EL PASO COUNTY GRADING AND EROSION CONTROL PLAN CHECKLIST

PPR-22-059. Unresolved.

SHEET
IDENTIFICATION
EC2

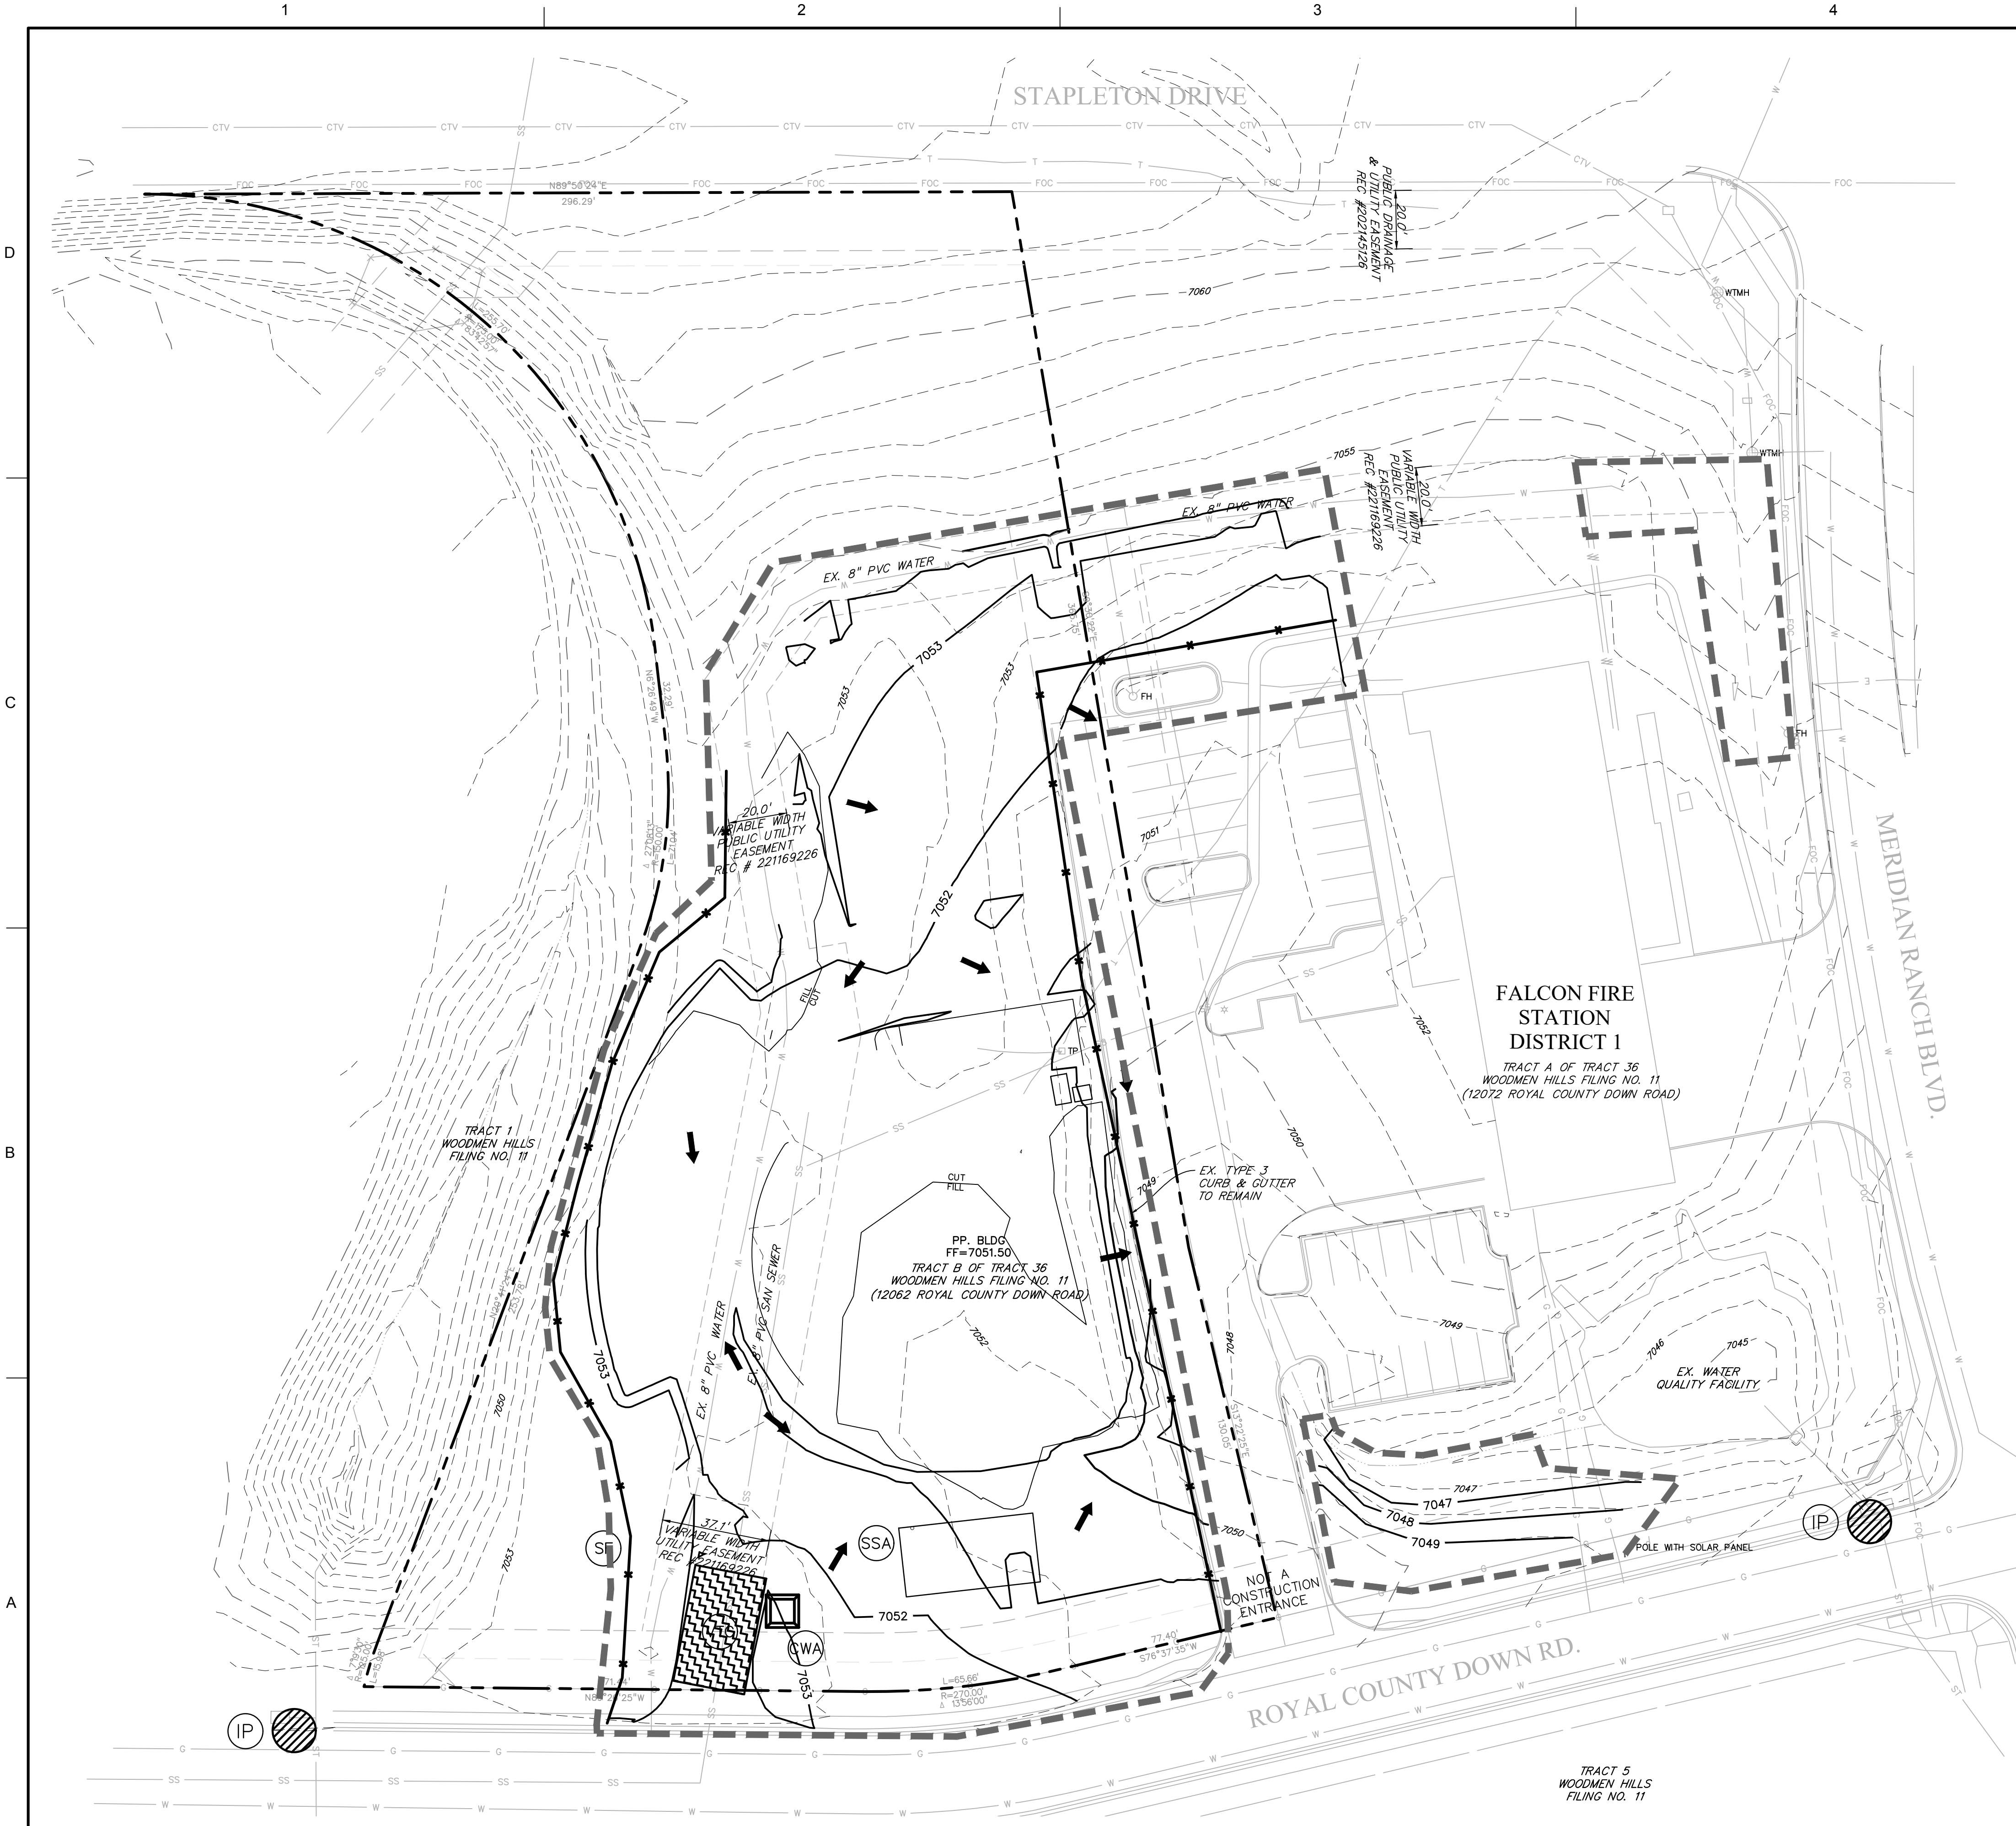
Applicant	EPC
1. GRADING AND EROSION CONTROL PLAN			
a	Vicinity map		✓
b	Adjacent city/town/jurisdictional boundaries, subdivision names, and property parcel numbers labeled		✓
c	North arrow and acceptable scale (1"=20' to 1"=100')		✓
d	Legend for all symbols used in the plan		✗
e	Existing and proposed property lines. Proposed subdivision boundary for subdivision projects		✓
f	All existing structures		✓
g	All existing utilities		✓
h	Construction site boundaries		✓
i	Existing vegetation (notes are acceptable in cases where there is no notable vegetation, only grasses/weeds, or site has already been stripped)		✓
j	FEMA 100-yr floodplain		N/A
k	Existing and proposed water courses including springs, streams, wetlands, detention ponds, stormwater quality structures, roadside ditches, irrigation ditches and other water surfaces. Show maintenance of pre-existing vegetation within 50 feet of a receiving water		✓

v	All proposed temporary construction control measures, structural and non-structural. Temporary construction control measures shall be identified by phase of implementation to include "initial," "interim," and "final" or shown on separate phased maps identifying each phase		✓
w	Vehicle tracking provided at all construction entrances/exits. Construction fencing, barricades, and/or signage provided at access points not to be used for construction		✗
x	Temporary sediment ponds provided for disturbed drainage areas greater than 1 acre		✓

**SHEET
IDENTIFICATION
DT1**

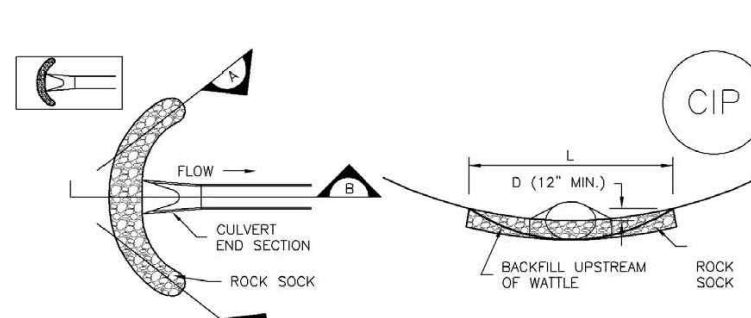
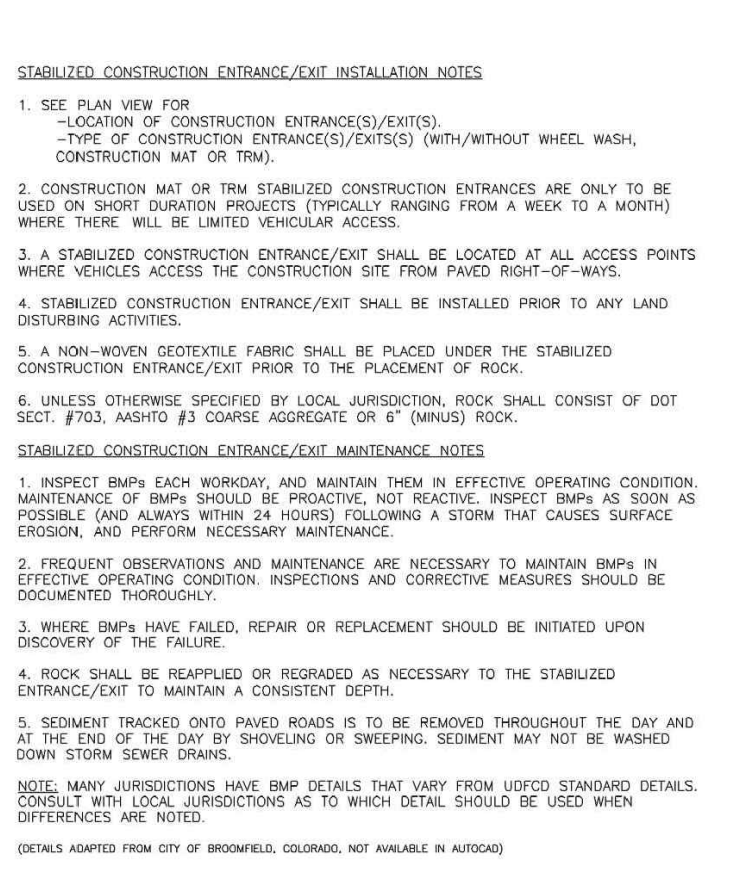
Applicant	EPC
y	Dewatering operations to include locations of diversion, pump and discharge(s) as anticipated at time of design		N/A
z	All proposed temporary construction control measure details. Custom or other jurisdiction's details used must meet or exceed EPC standards		X
aa	Any off-site stormwater control measure proposed for use by the project and not under the direct control or ownership of the Owner or Operator		✓
bb	Existing and proposed permanent storm water management facilities, including areas proposed for stormwater infiltration or subsurface detention		✓
cc	Existing and proposed easements (permanent and construction) including required off-site easements		✓
dd	Retaining walls (not to be located in County ROW unless approved via license agreement). Design by P.E. and building permit from Regional Building Department required for walls greater than or equal to 4 feet in height, series of walls, or walls supporting a surcharge		N/A
